**Subject:** AU-24-00006 Firl - Notice of Application

**TO:** All Staff  
**FROM:** Public Works Plan Review Team  
**DATE:** November 7, 2024  
**SUBJECT:** AU-24-00006 Firl

SITE PLAN

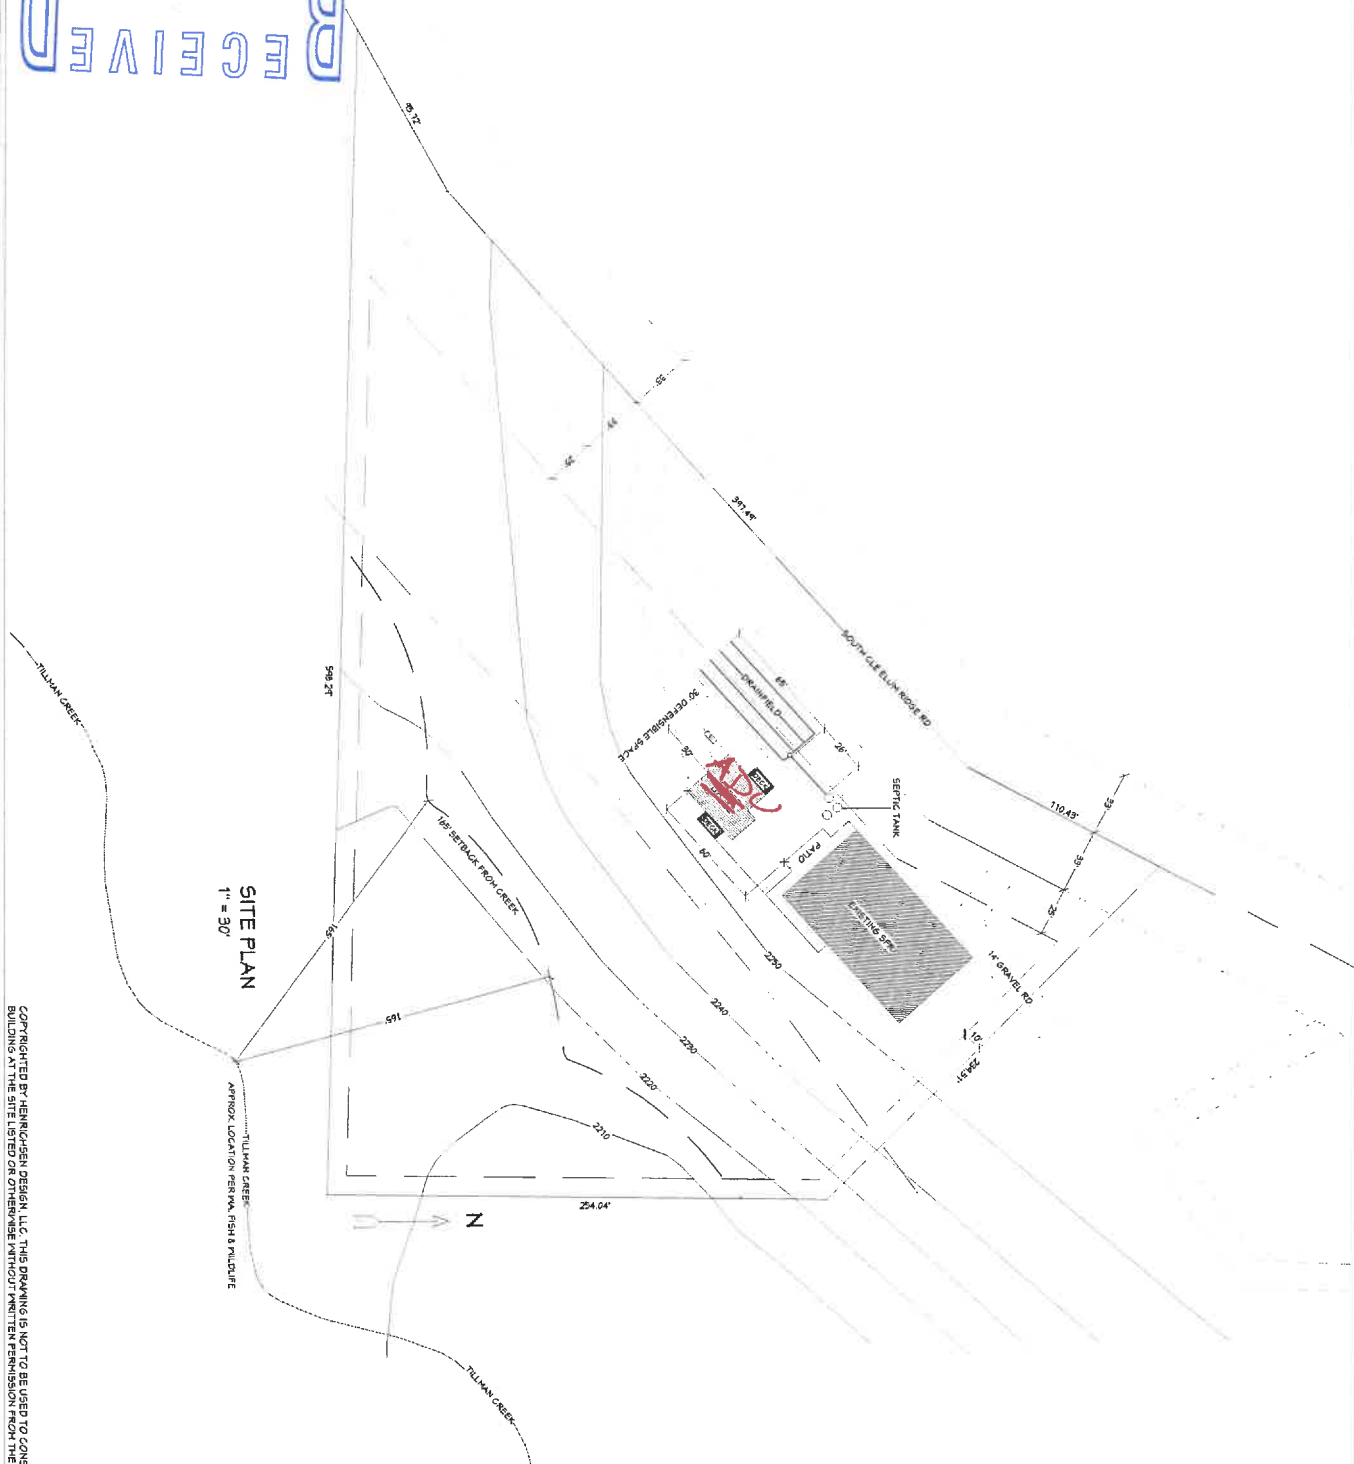
Thank you for the opportunity to review and comment on AU-24-00006, which proposes the addition of an accessory dwelling unit (ADU) on Kittitas County parcel 956834. The Washington Department of Fish and Wildlife had a site visit on this parcel in 2022 to map the location of Tillman Creek, a perennial fish-bearing tributary to the Yakima River. Tillman Creek is present near the southeastern corner of the parcel and is correctly labeled on the applicant's site plans and we appreciate the setback buffer labeled as well. We have no further comments on the proposal.
